Our Ref: TR010043

Date: 28 May 2019

Application by Norfolk County Council for an Order Granting Development Consent for the Great Yarmouth Third River Crossing

Advice following issue of decision to accept the application for examination

**DRAWING TITLE**  
DCO DOCUMENT 2.6  
WORKS PLAN  
SHEET 1 OF 7  
(REGULATION 5(2)(j))

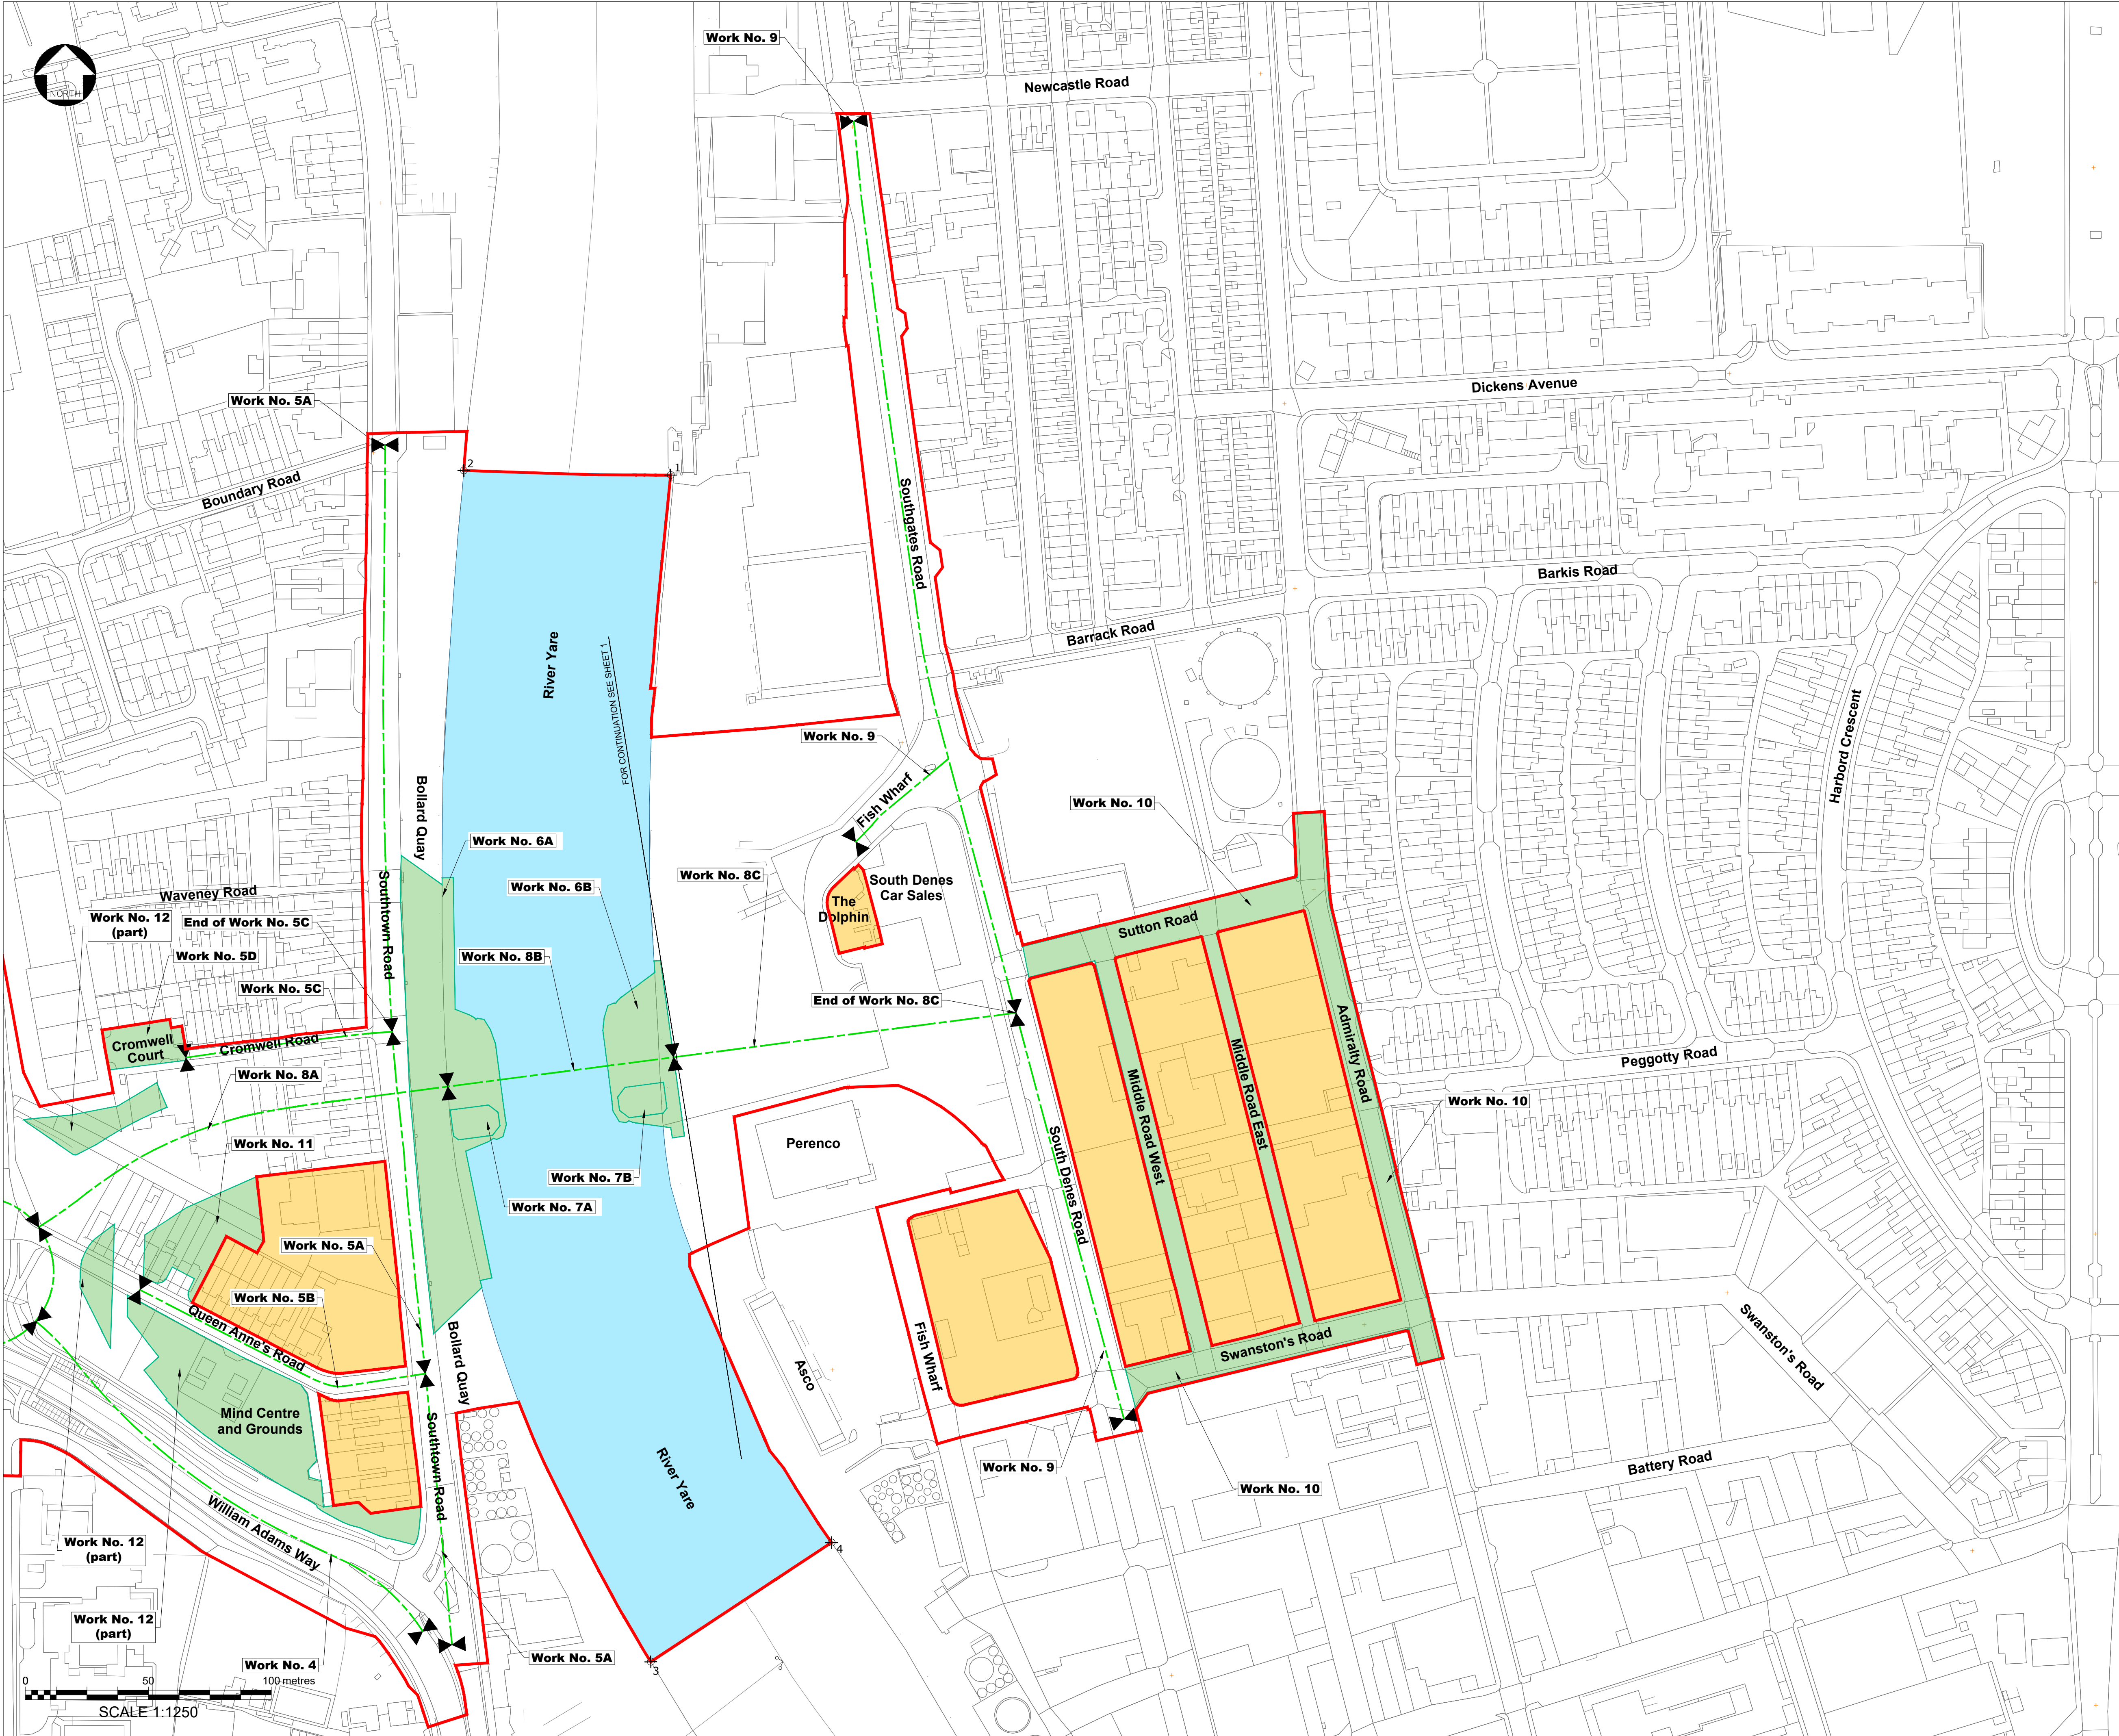
- On Sheet 1, Work No. 2 is depicted using centre lines, however the DCO describes a compound between William Adams Way and Queen Anne's Road, this description and depiction allows for a wide variety of location options. Specifying the location will allow Interested Parties to more fully understand potential impacts.
- On Sheet 1, Work No. 5b has two labels pointing to different roads; only one of the labels appears to match the description of the works in the DCO.
- On Sheet 2, Work No. 9 is made up from 2 centre lines. These lines do not appear to be sufficient to depict all the works described in the DCO, particularly Work No. 9 c, d, e and f.
